Re: Objection to MP08_0244 MOD 1 Modification Request for Mixed Used Development at 23-37 Lindfield Avenue and 11 Havilah Lane, Lindfield

As a resident of Lindfield, I/we wish to lodge an objection against the proposed Modification of the subject development based on the following grounds:

1 SHADOW DIAGRAM - 21stDEC_9AM
5003 SCALE1 : 650

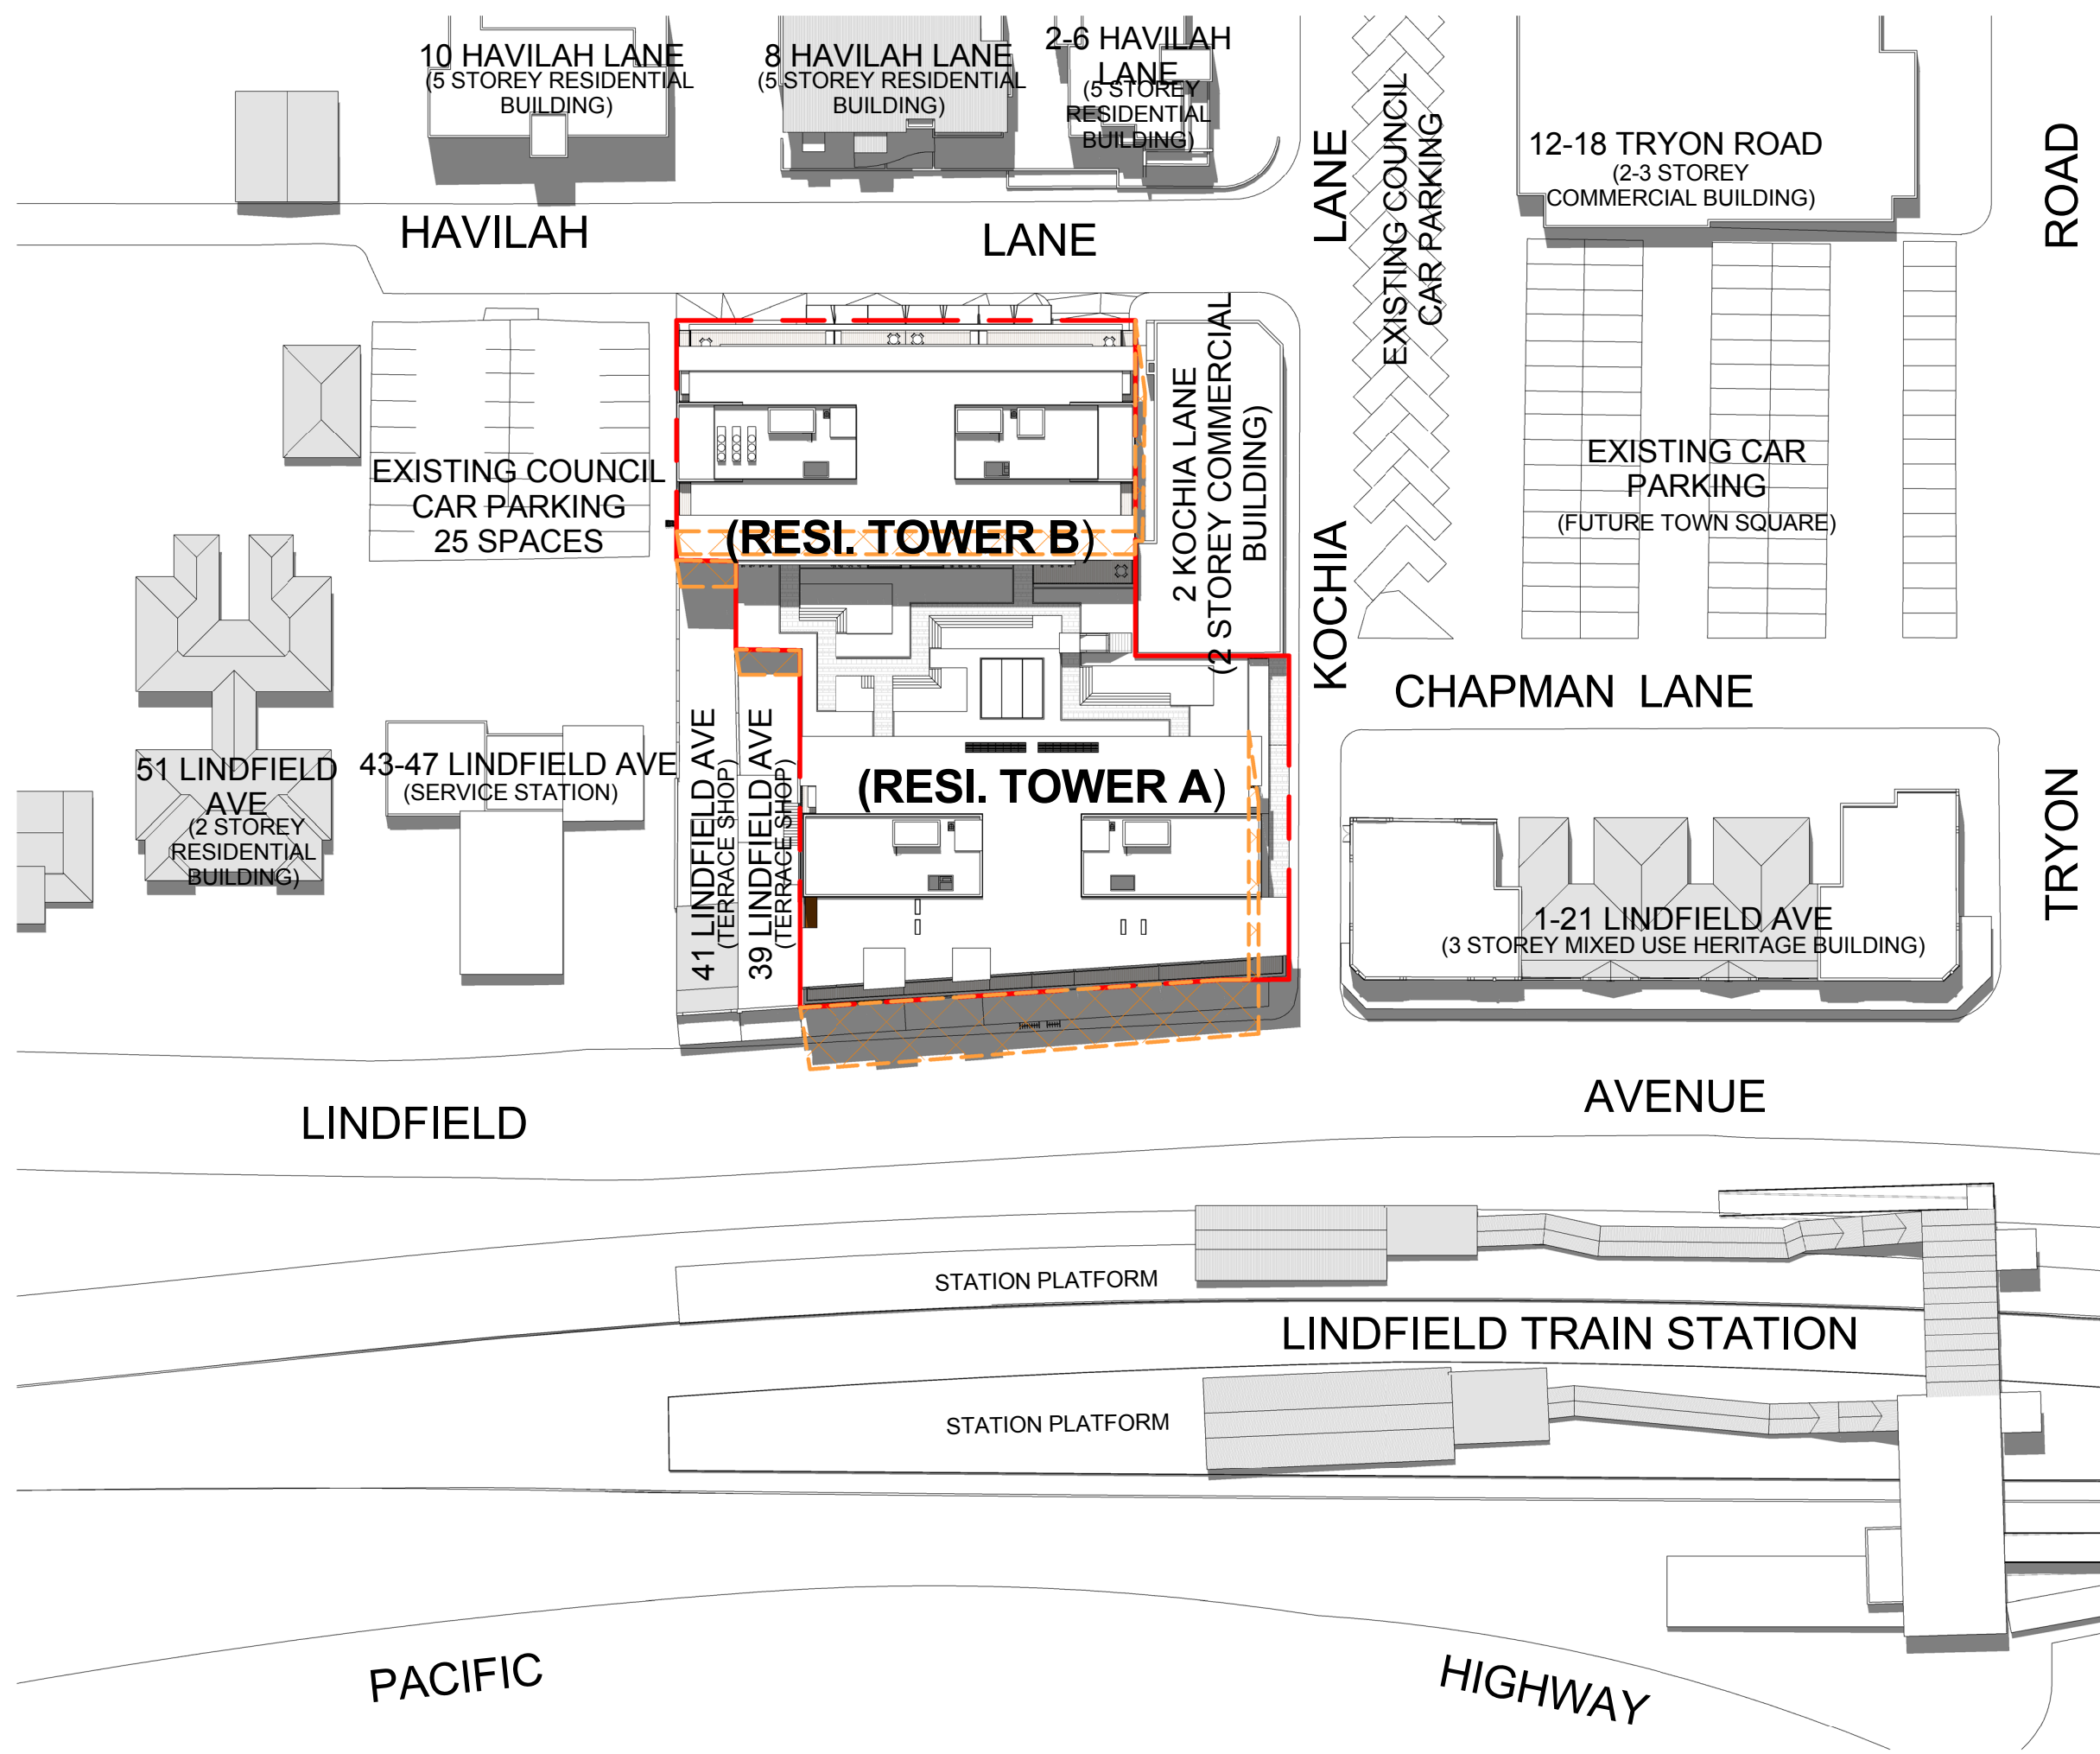
- ✓ The additional storeys create new adverse shadowing: a) for residents in the Havilah Lane apartments, particularly after 3pm b) for the popular outdoor café and central Lindfield hub area at 12 Tryon Road in afternoons, particularly in winter and c) for all commuters on the city bound Lindfield rail platform, instead of 50% of the year as approved, it will now be in shadow in the mornings 75% of the year
